**RE: PUDSP-21-010 – GRANDVIEW RESERVE (WITH PSSG) SECOND SUBMITTAL Comment MEMO.**

**File No.: PUDSP2110**

Below are the comments from the Planning & Community Development comment memo (issued 1/23/2022) on the above referenced project along with our response in ***bold and italics***:

C2.01
Sheet 7 of 40

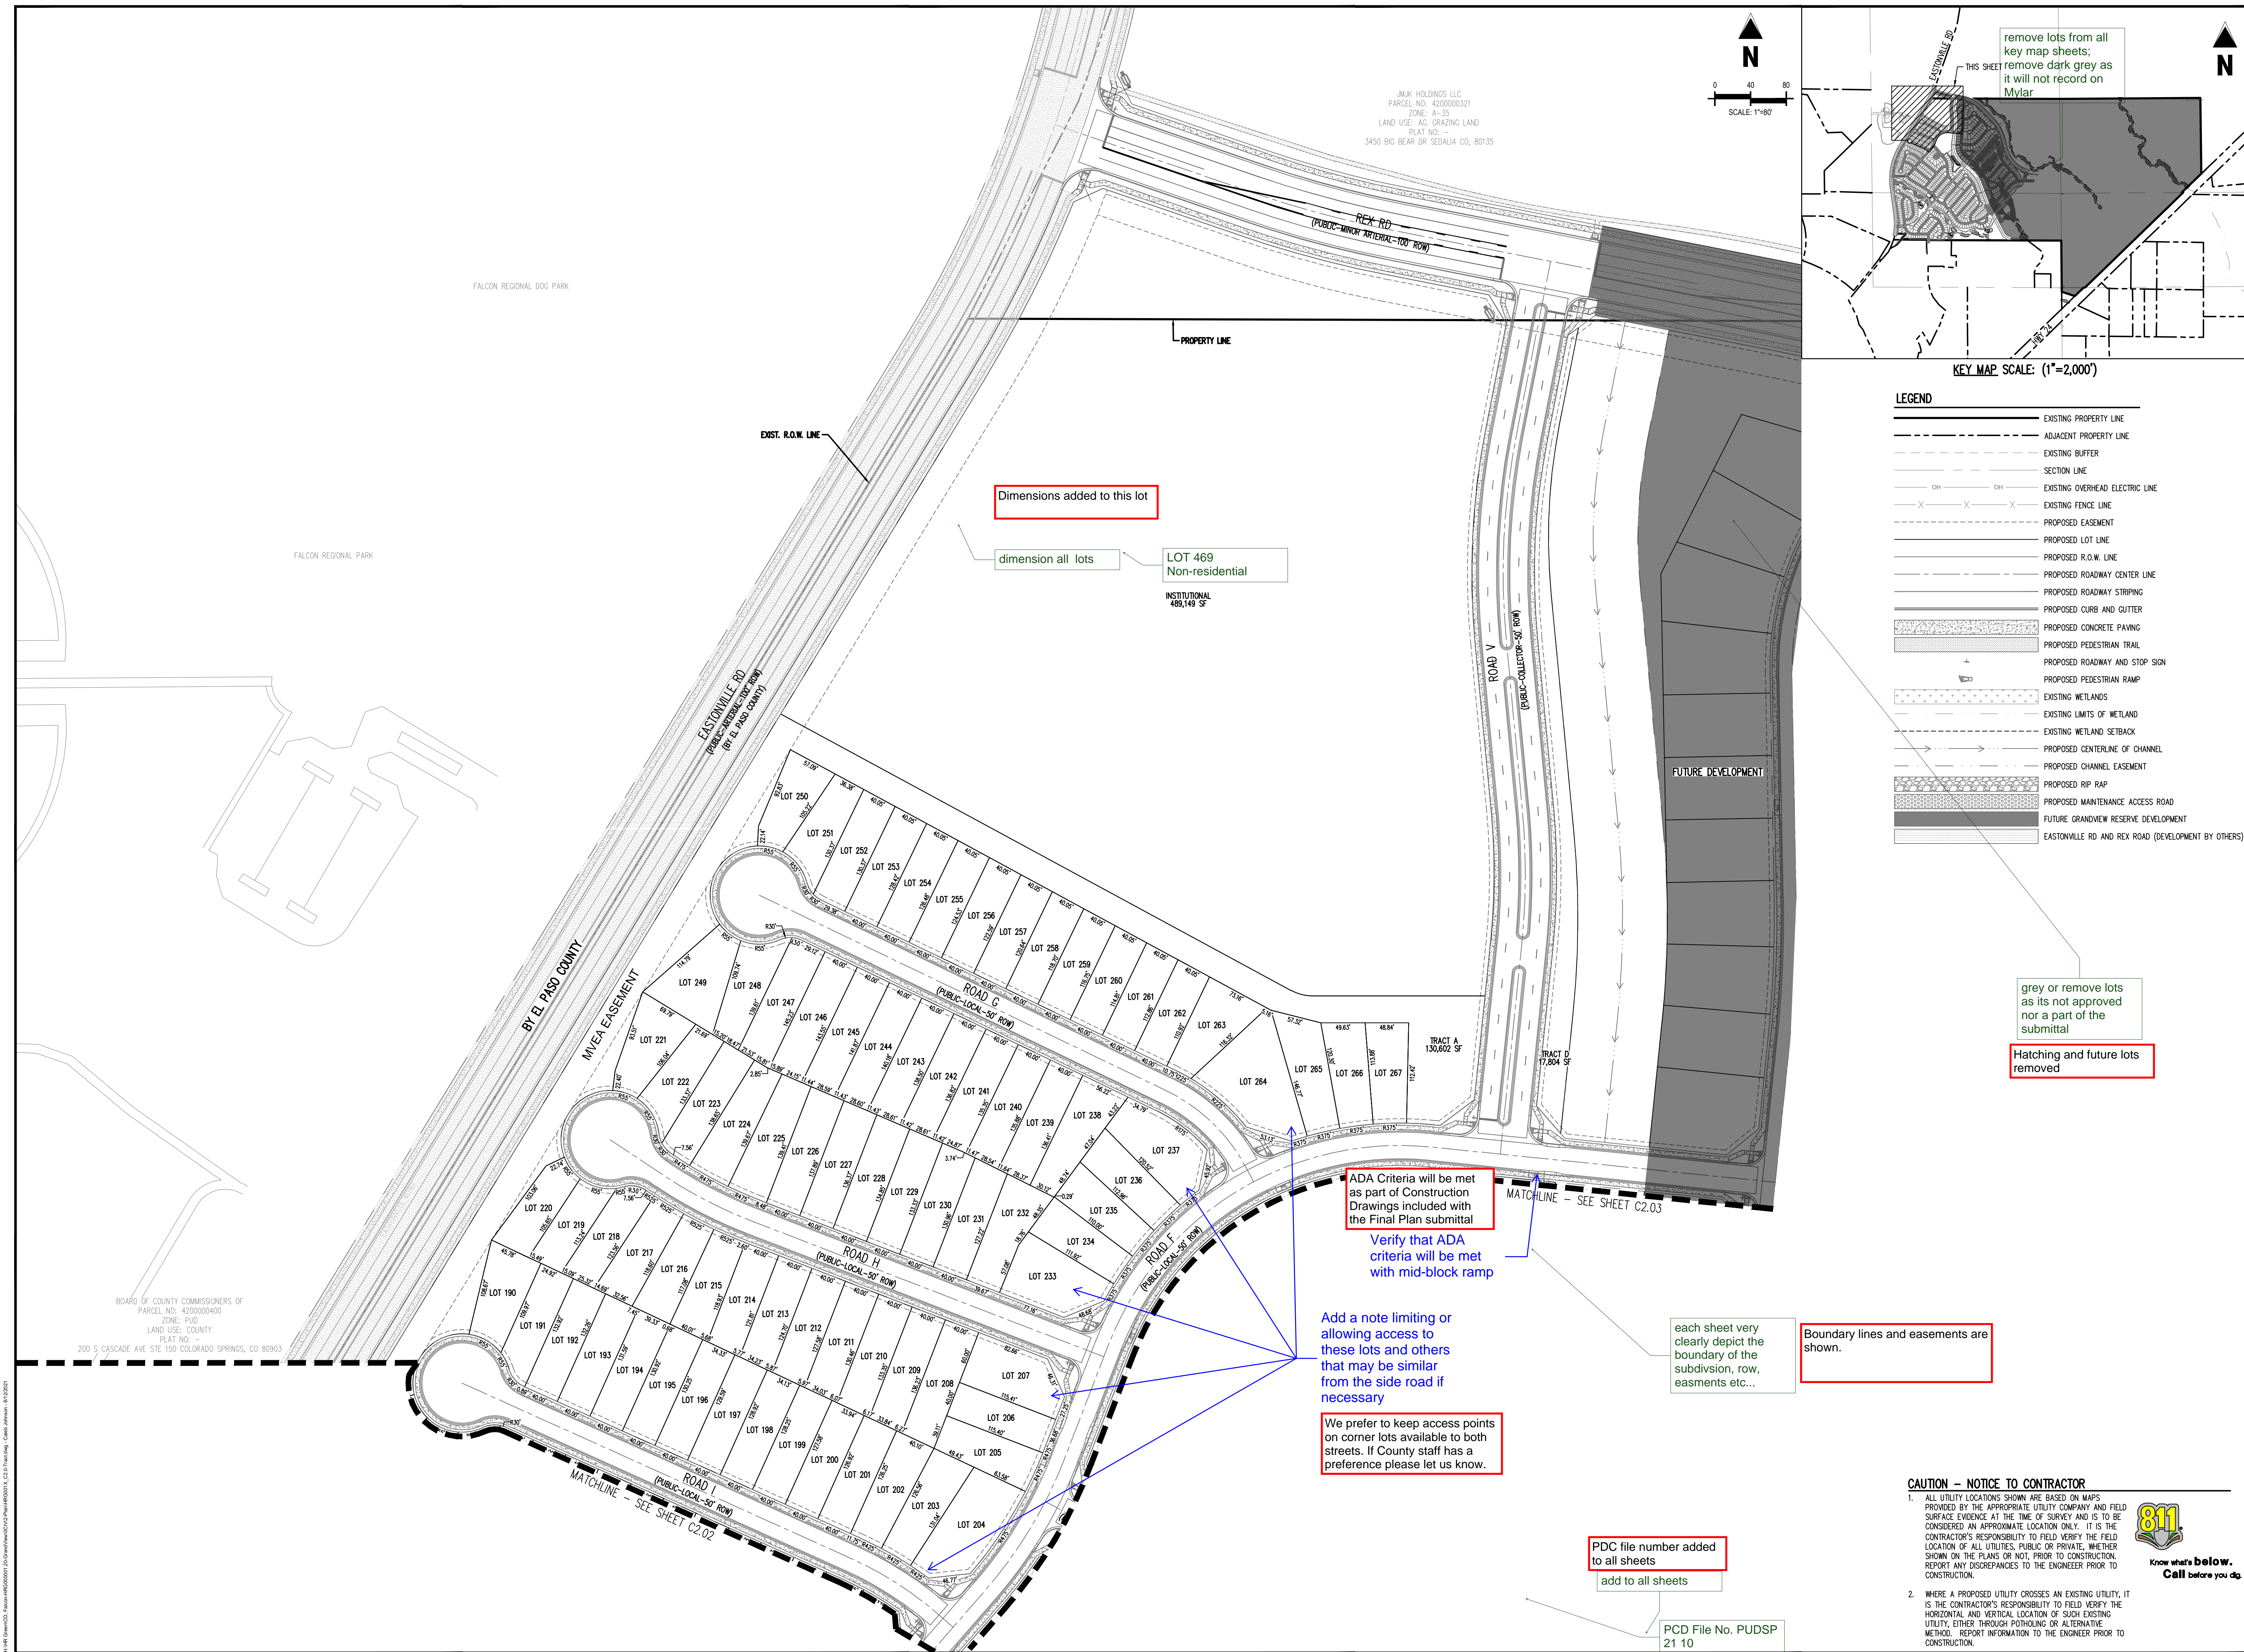
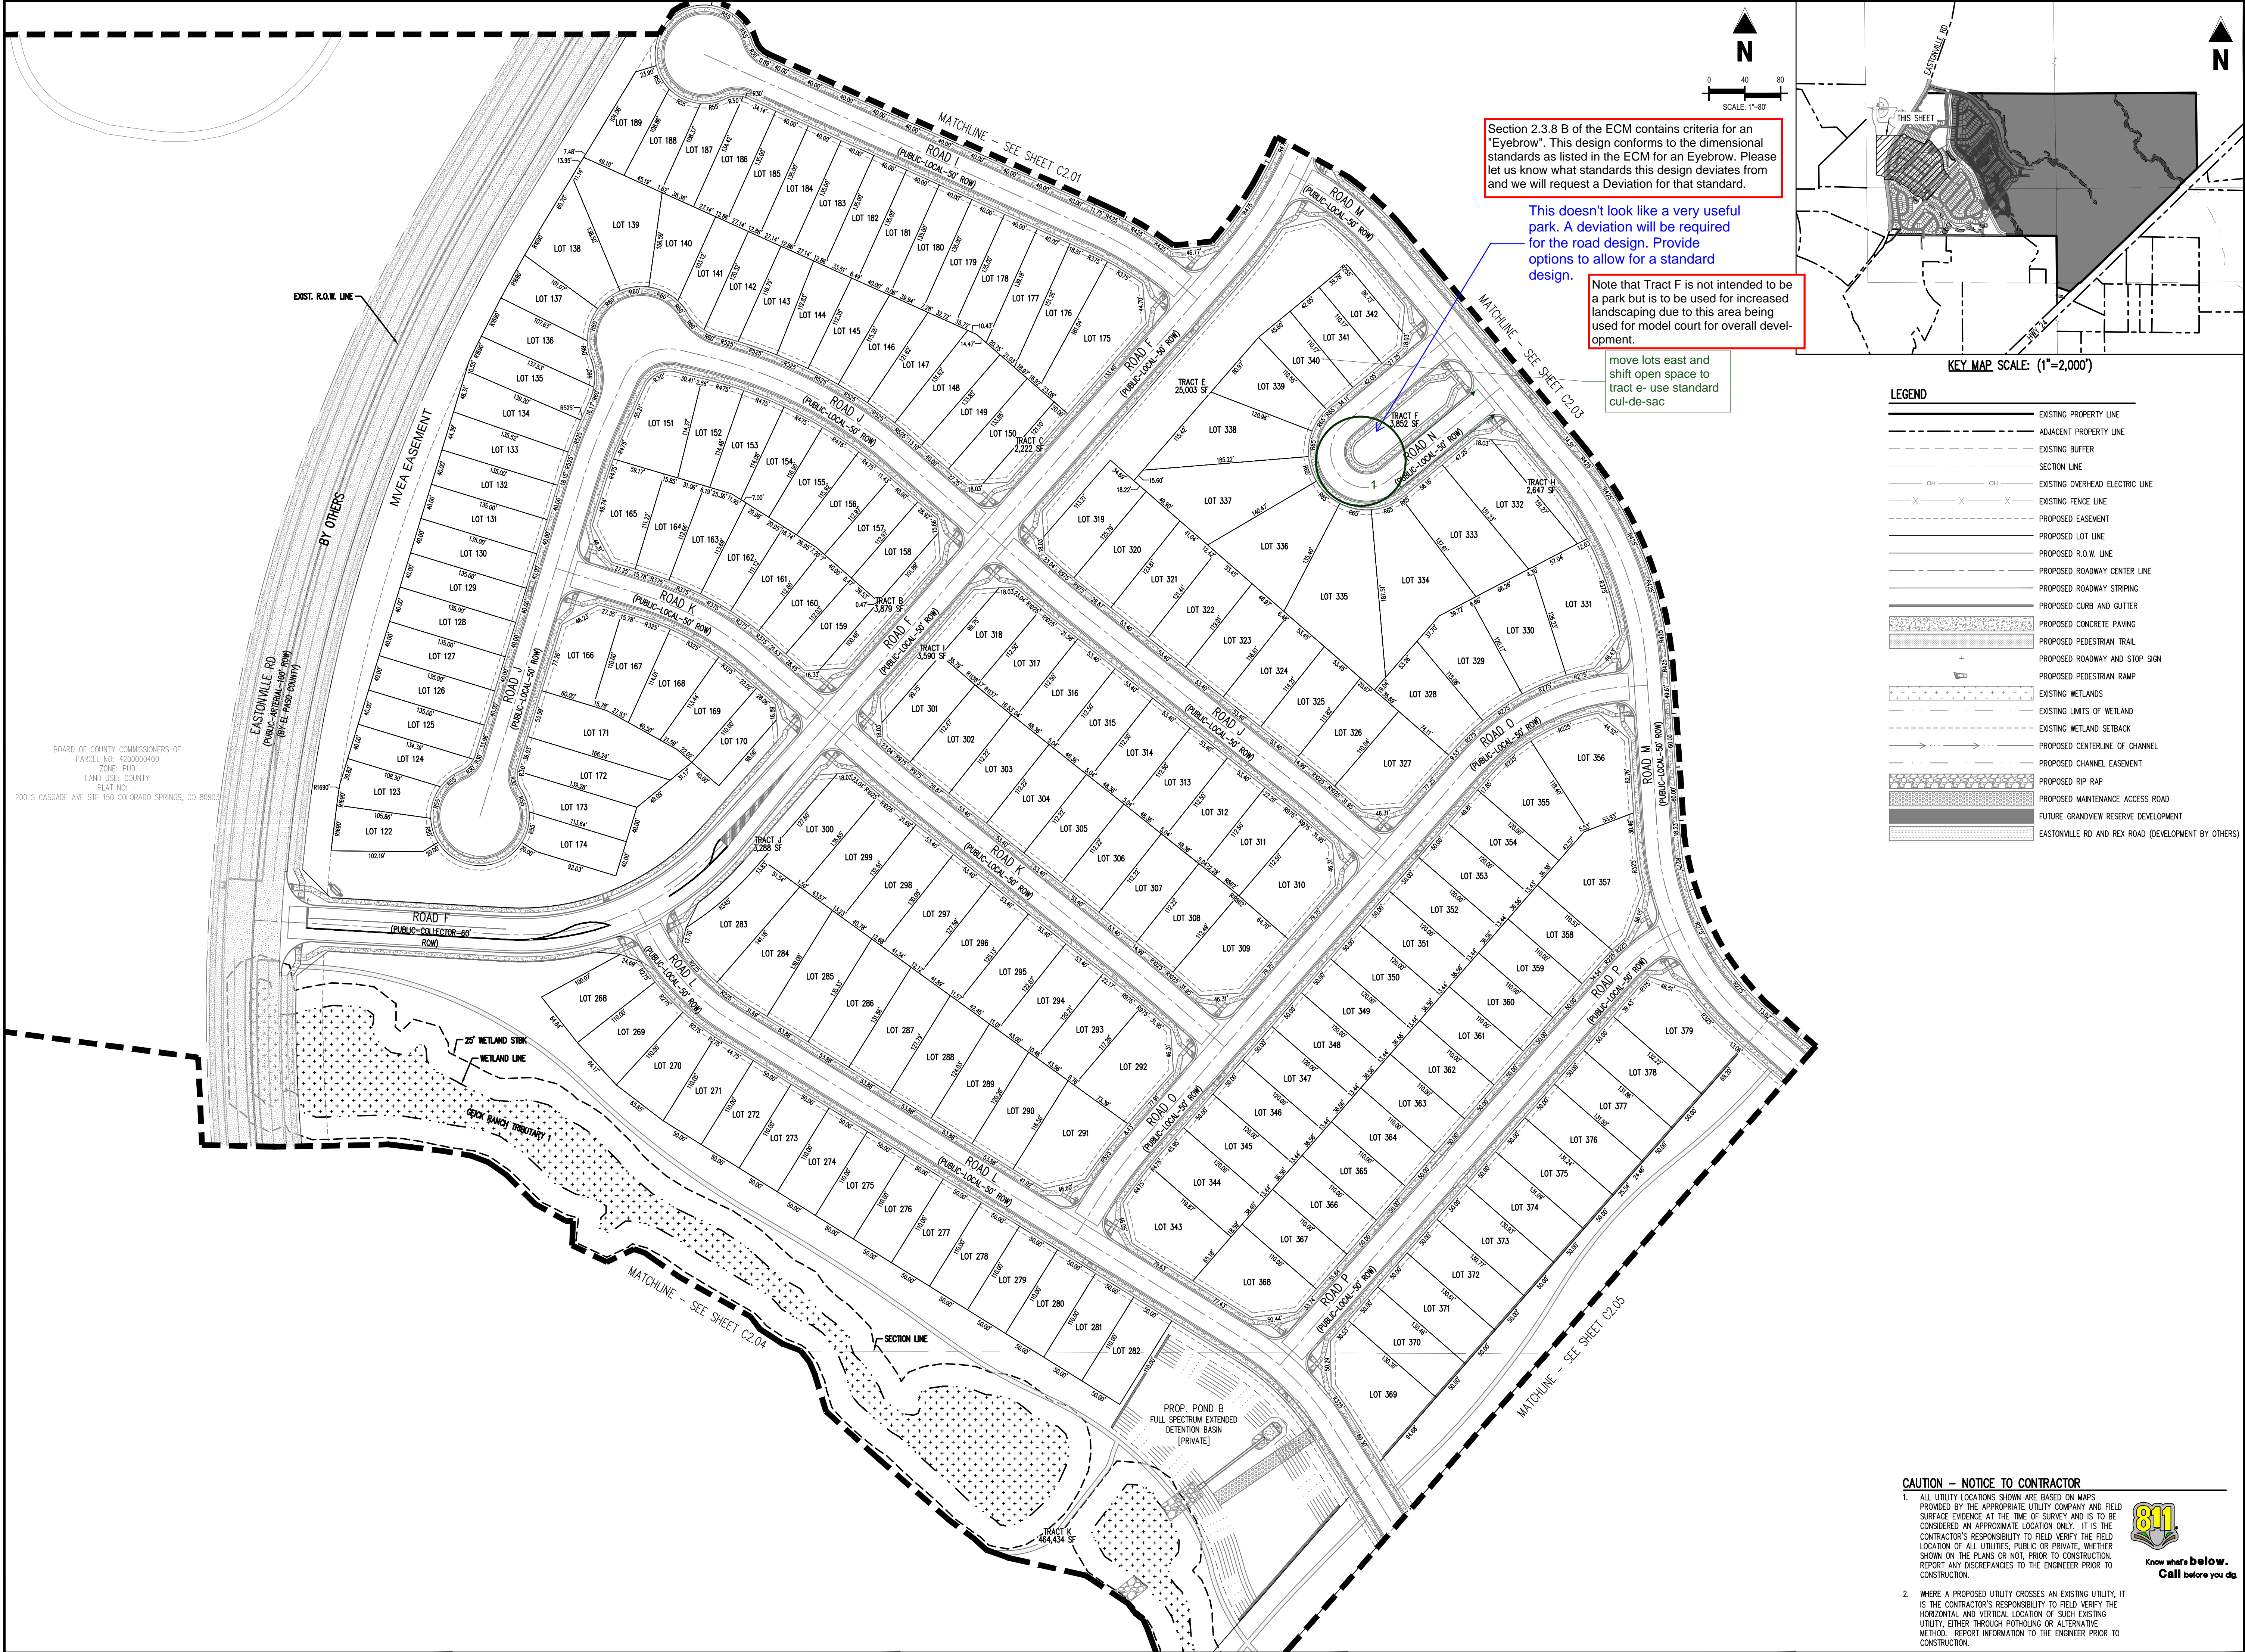
- f. **Eyebrow design on Sheet C3.2:** The design proposed exceeds the maximum length (100' from ROW to center of island radius) per ECM Figure 2-32, and that design is proposed for revision to be a maximum of 45 feet, with no island in the next ECM update. If a deviation is requested, it should be for a shorter length and without sidewalk around the inner island (only at the crossing).  
*Response: The applicant has worked with the County (specifically Elizabeth Nijkamp) on the design of this model home court. We have come to agreements on the general layout. It is our understanding a formal deviation request is not needed based on our conversations with Elizabeth Nijkamp.*

L1.20

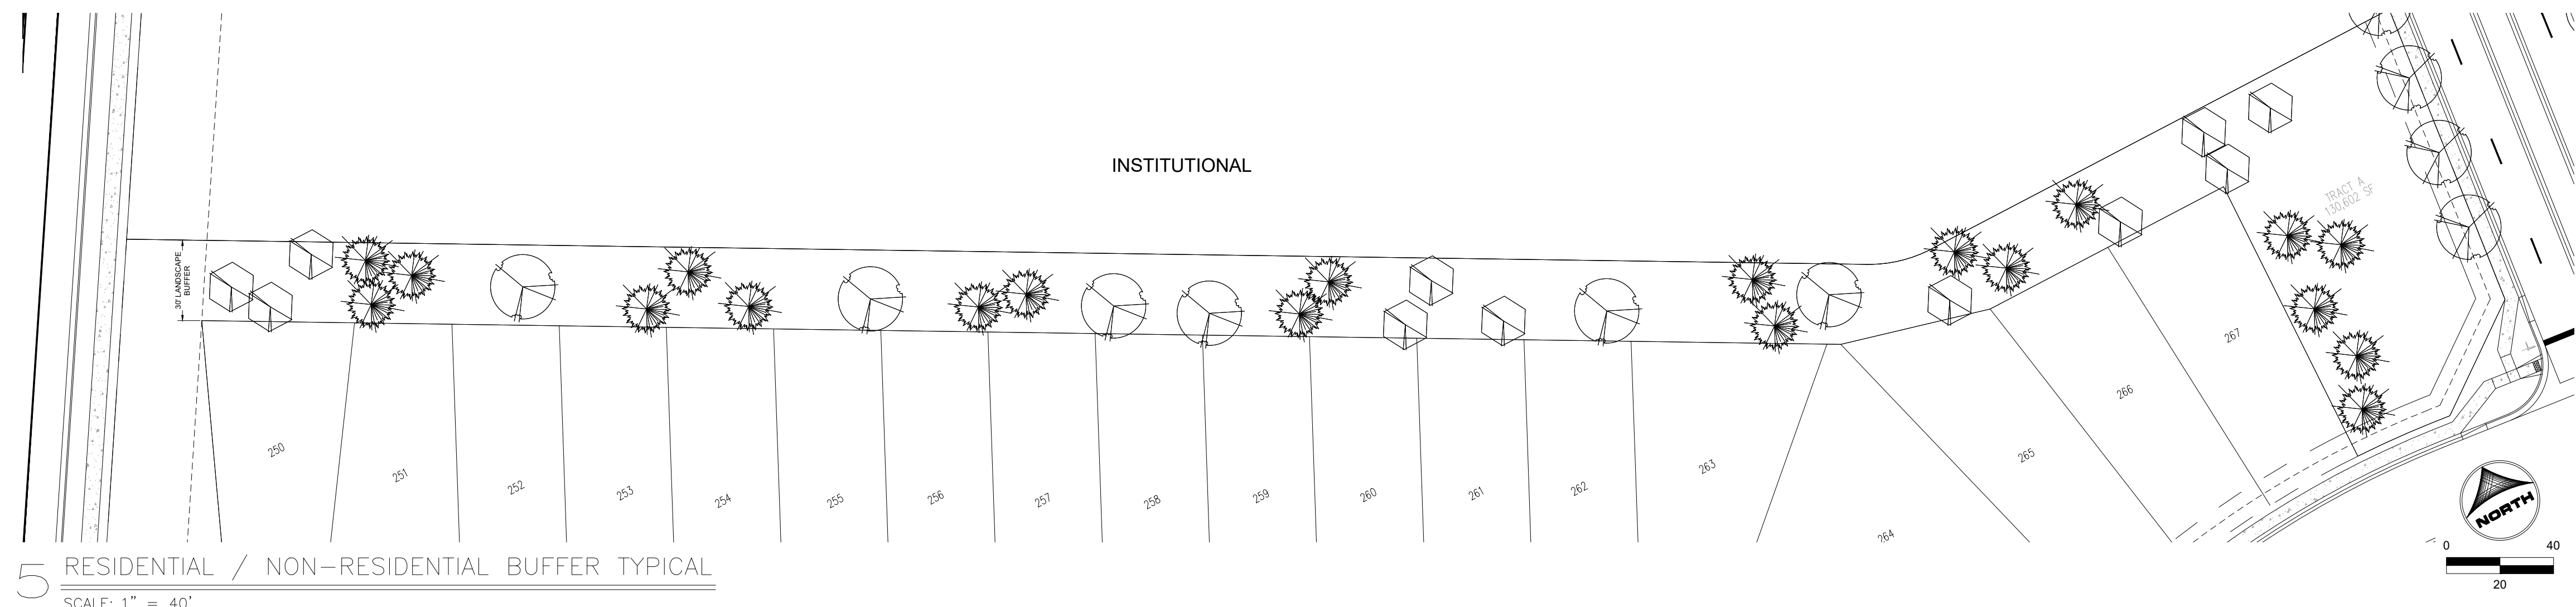
11. **Detail #4 on Landscape Plan Sheet L1.1 needs revisions to the trees on the west side. They need to be outside the right-of-way, which needs to be behind the curb and gutter.**  
*Response: Trees have been removed from the right of way.*
